Appeal Decision

Decision date: 22 February 2022

Appeal Ref: APP/R5510/W/21/3281622

59 Elm Avenue, Ruislip HA4 8PE

Proposed Front Elevation
Scale 1:100

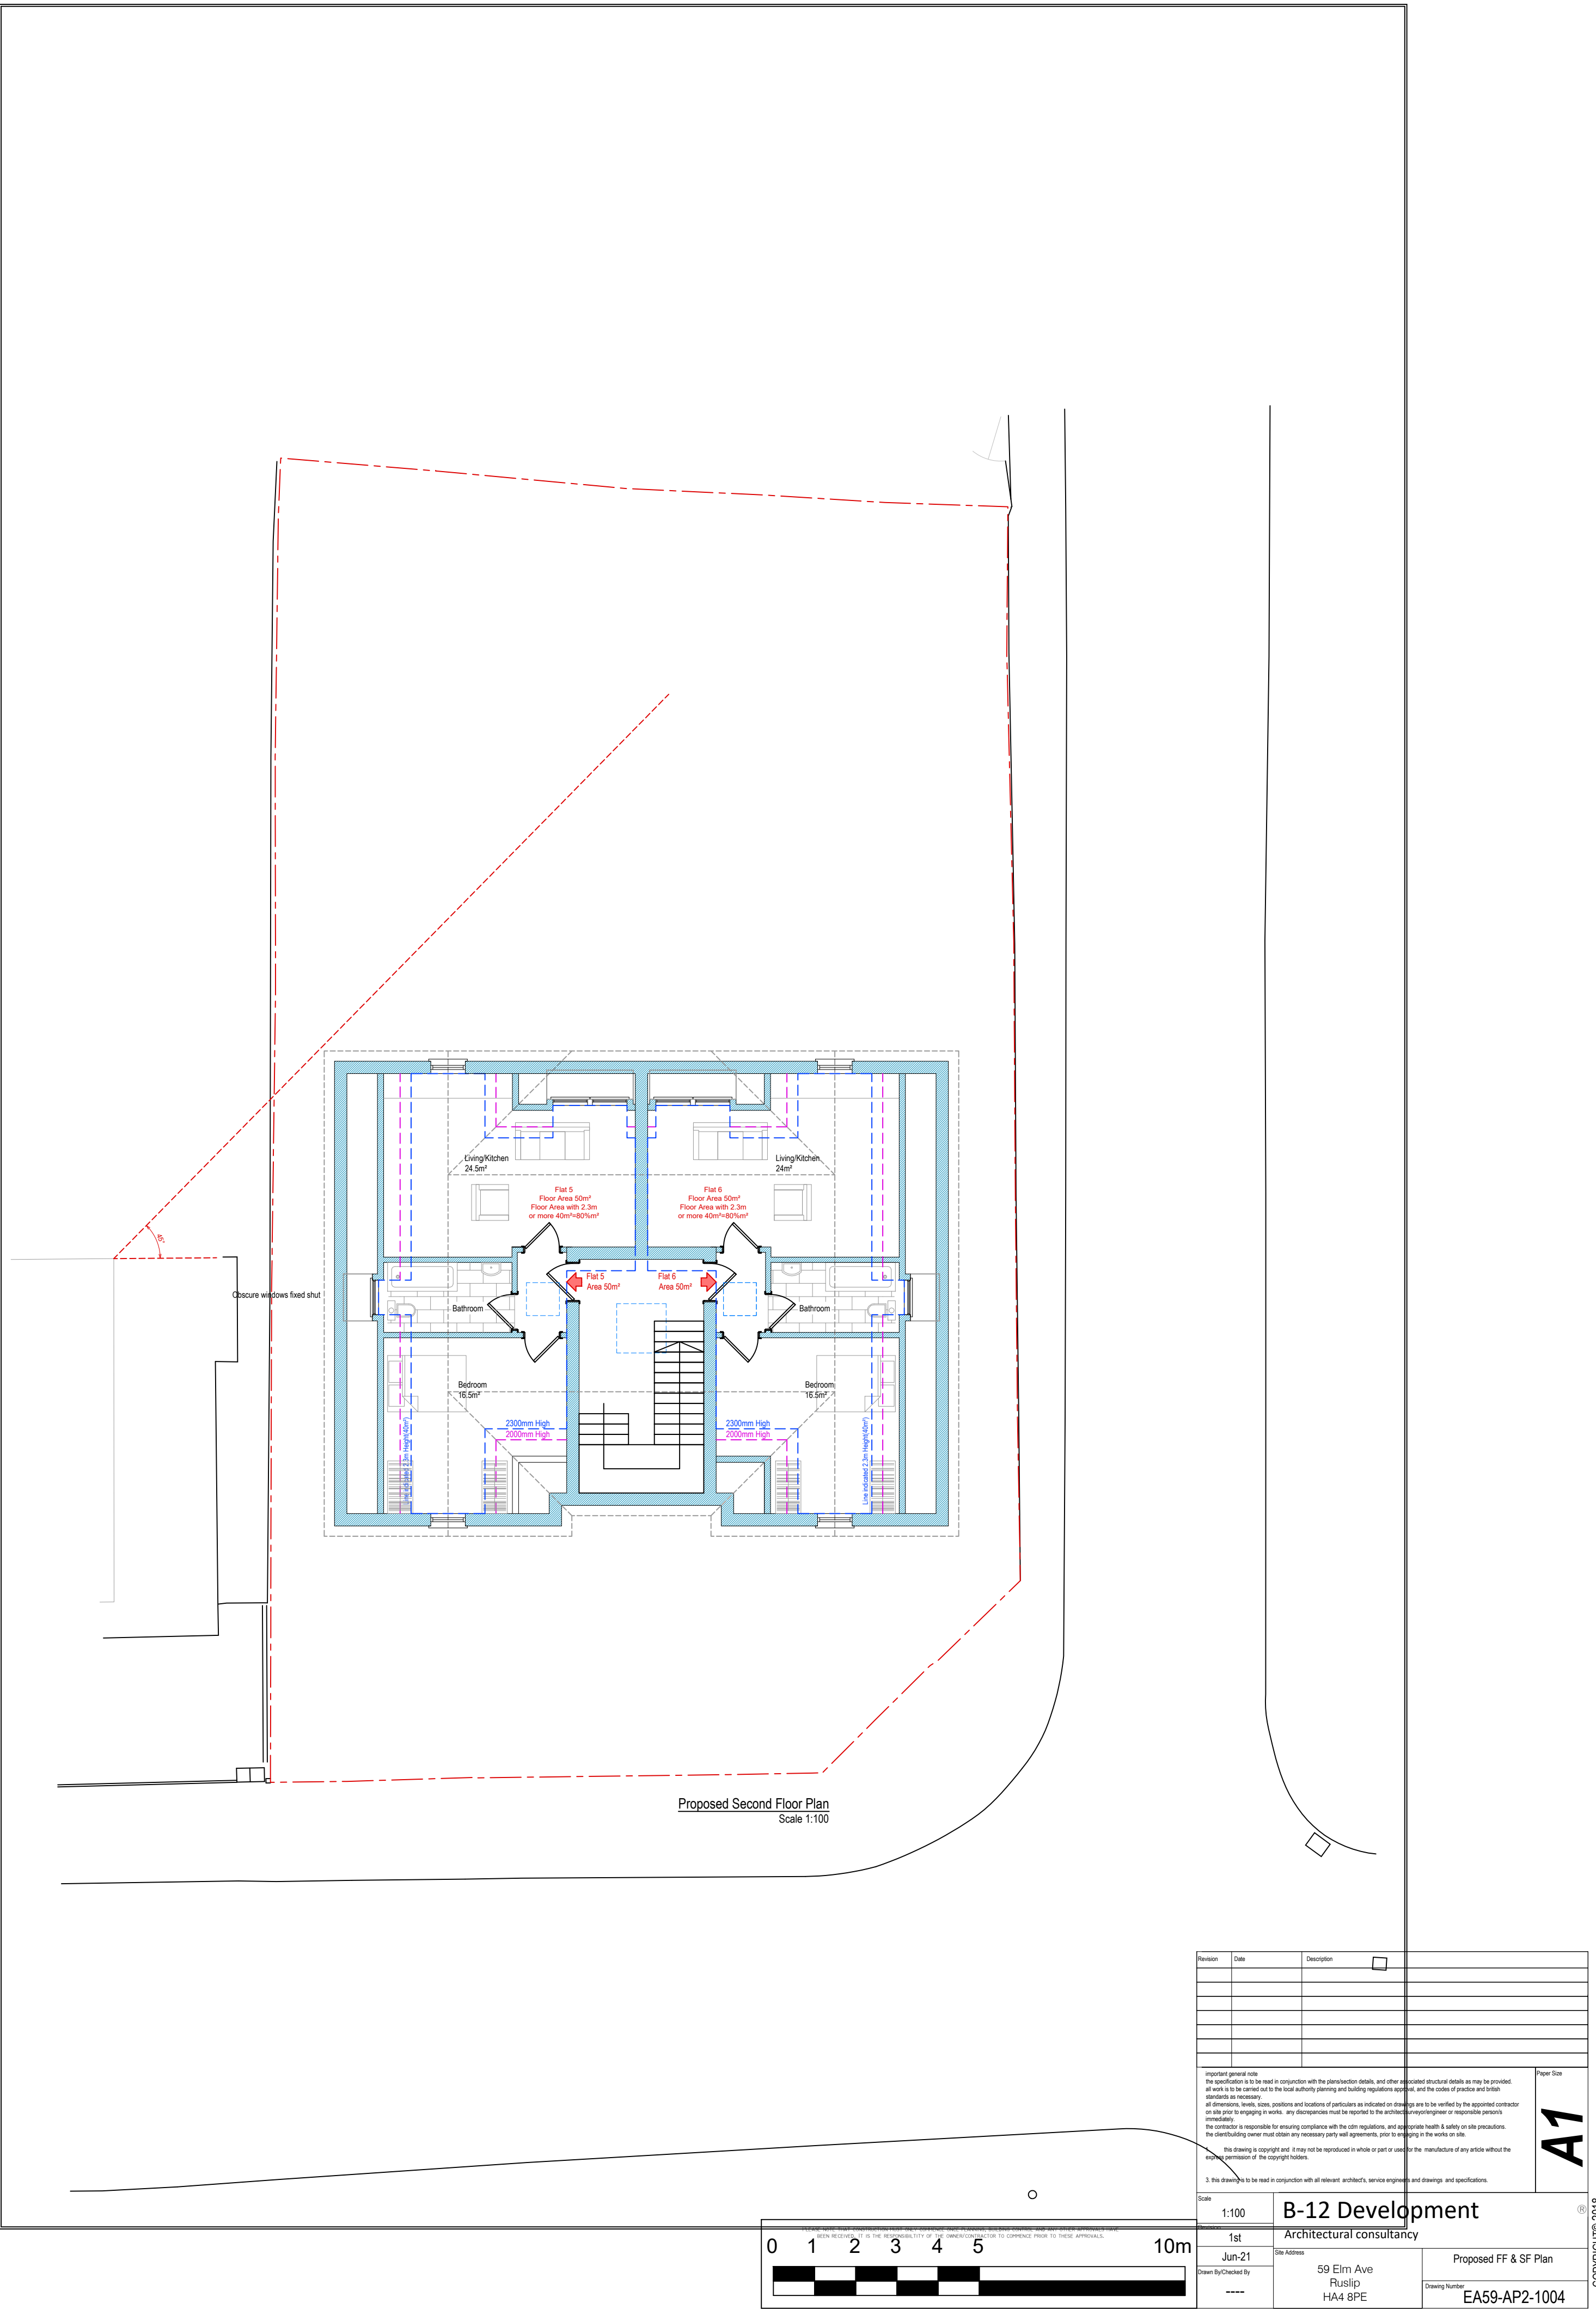
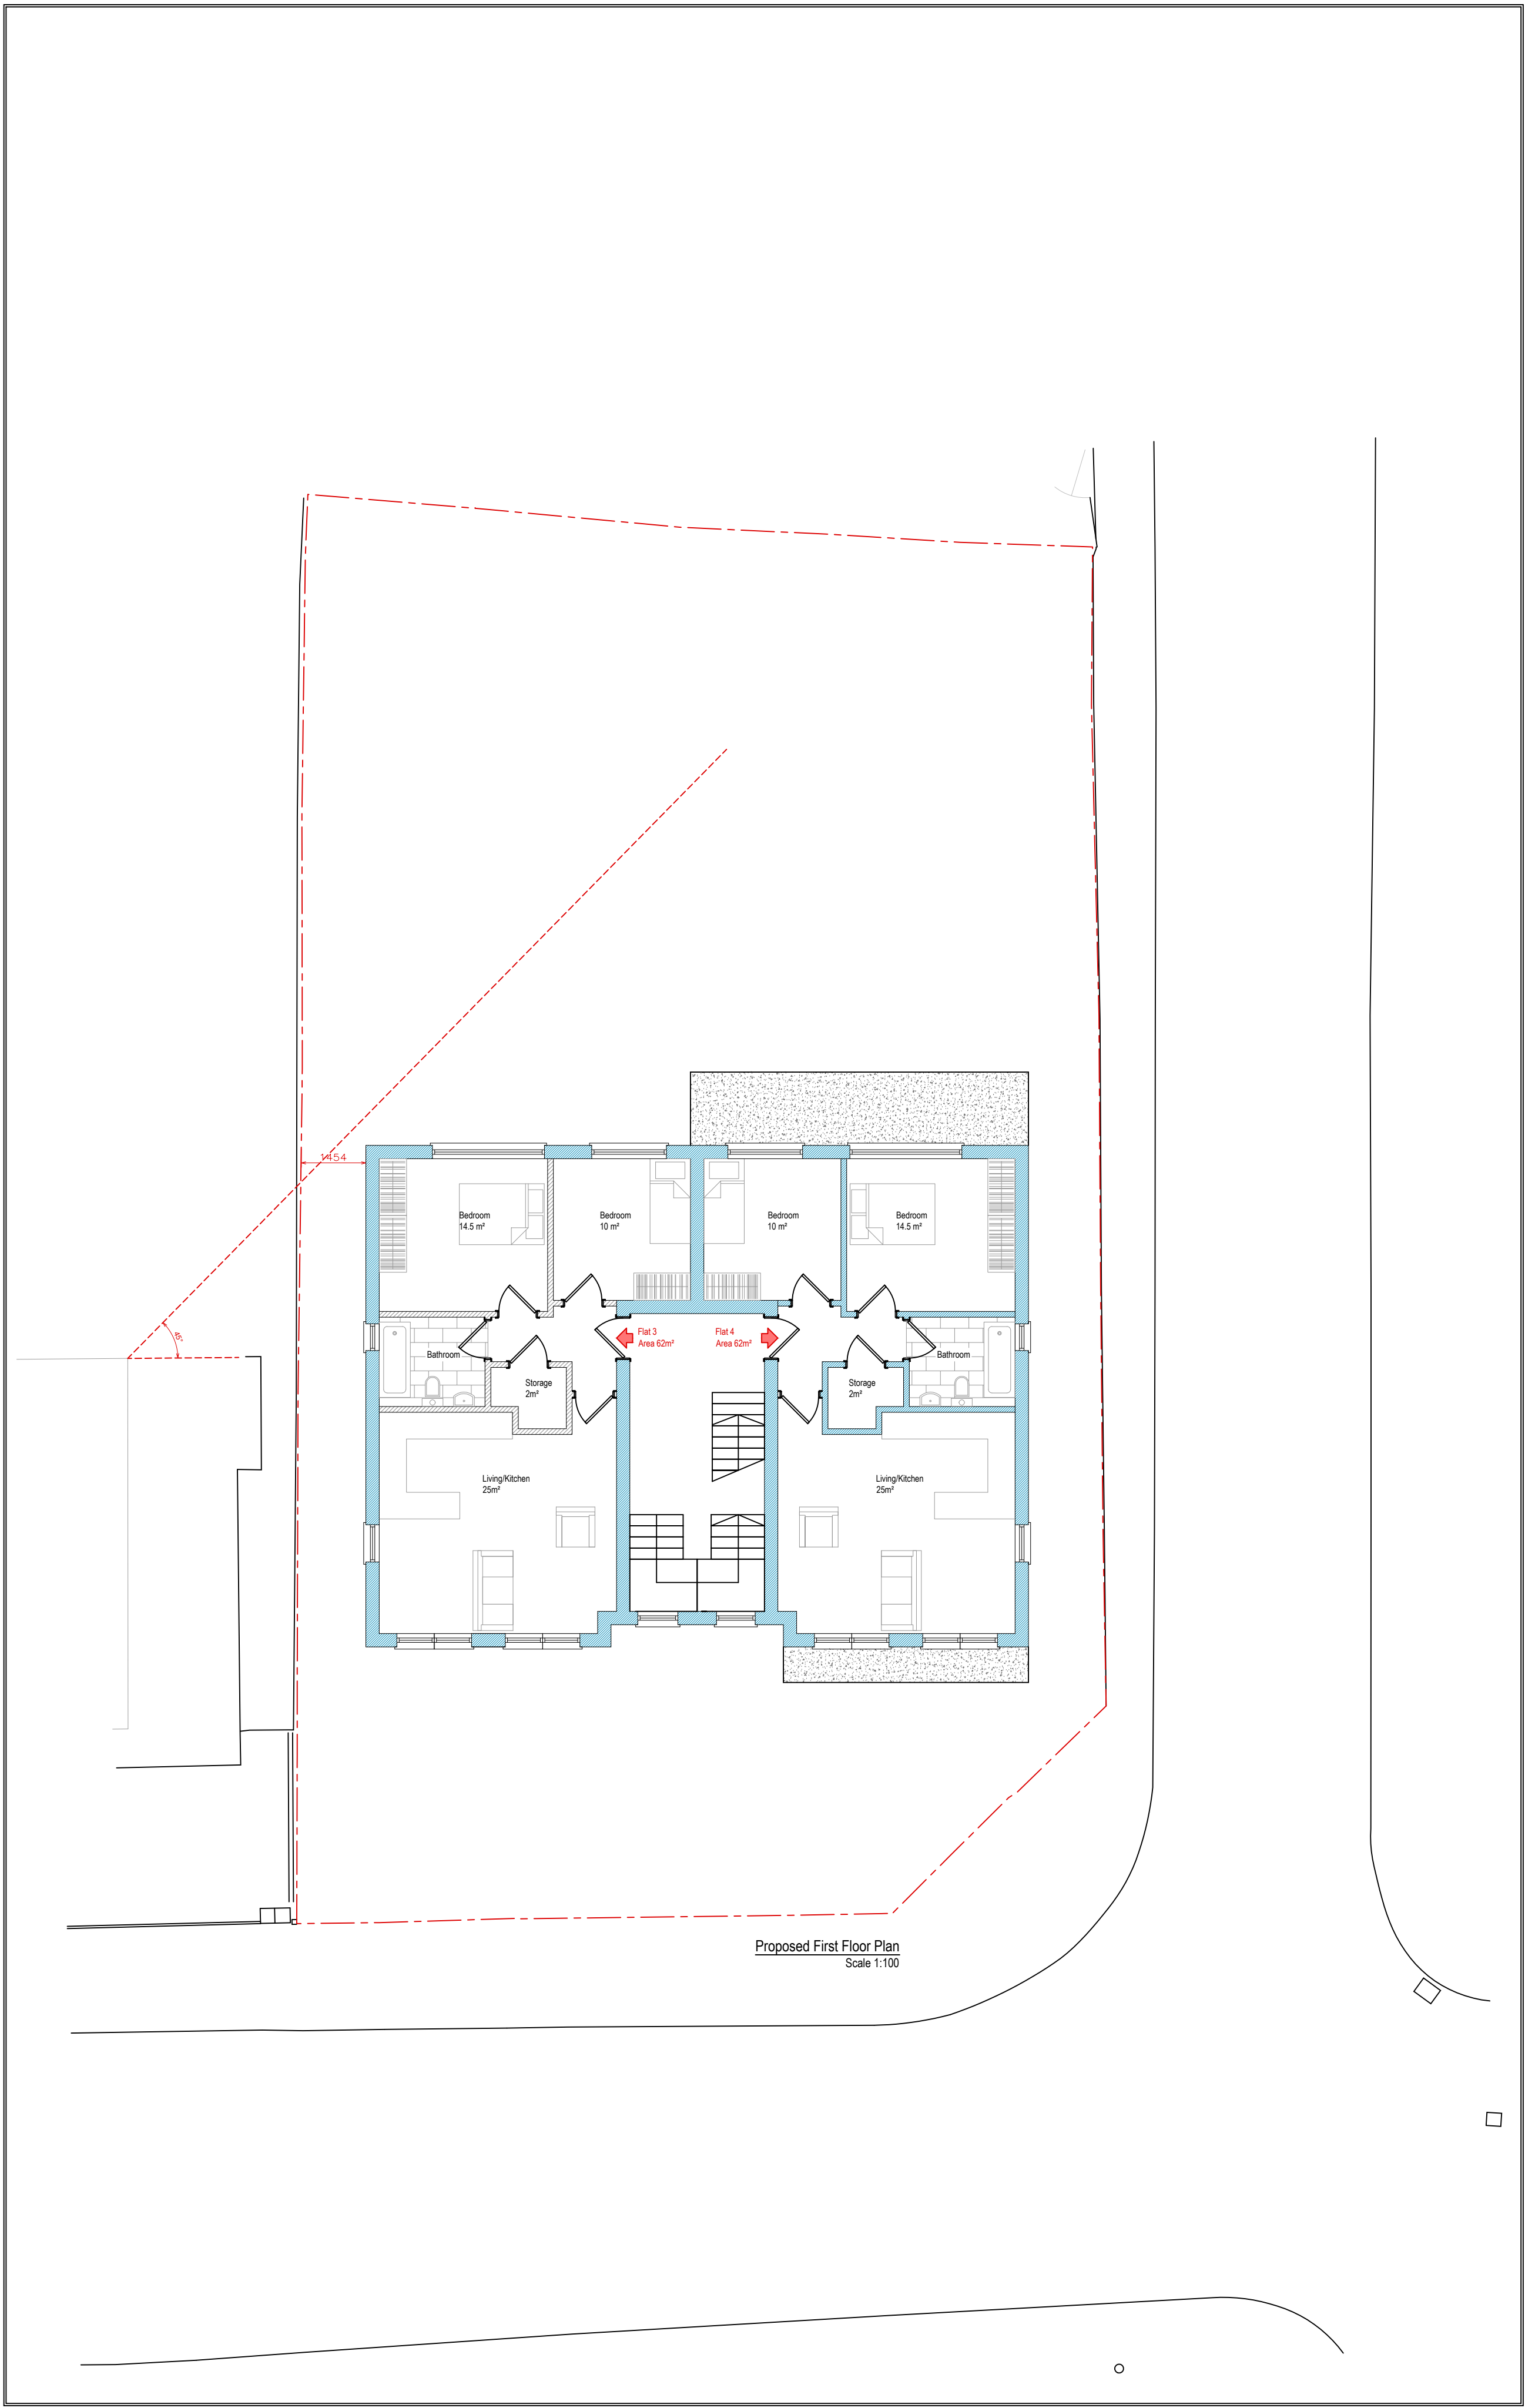
5. The design of the building as viewed from Elm Avenue would have two distinct gable features with a matching window pattern, giving the appearance of a semi-detached dwelling. However, the balance of the gables would be broken by a single storey flat roof projection to the front on one of the gables, resulting in an awkward and contrived feature. Although this is a small part of the scheme it would, nonetheless, undermine the overall quality of the design of the front presentation to the street.

6. The appellant has made changes to the design from previous proposals, including schemes considered at appeal. Whilst I have had regard to these decisions and there are similarities, there are also differences. The omission of the mock Tudor timber features within the gables has resulted in a design that would appear somewhat plain and lacking interest within the street scene, despite the split in materials from the ground and upper floors.

7. I have had regard to the appellant's suggestion that such detailing could be secured by way of a condition. I am conscious that the appeal process should not be used to progress alternatives to a scheme that has been refused. However, this would not, in any case, overcome my concerns in relation to the overall treatment of the front elevation in the street scene from the contrived front projection.

9. The single storey flat roof rear projection would not be prominent and such a feature would not appear at odds with its rear location, even though it would erode the balance of the rear elevation. The main roof of the building would have pitched slopes, such that the flat roof element would not be prominent in public views and would not be harmful in the street scene. The absence of harm in relation to these, and other elements of the design, including the positioning of the building within its plot and position and scale of dormers, do not outweigh my findings in relation to the overall quality of design.
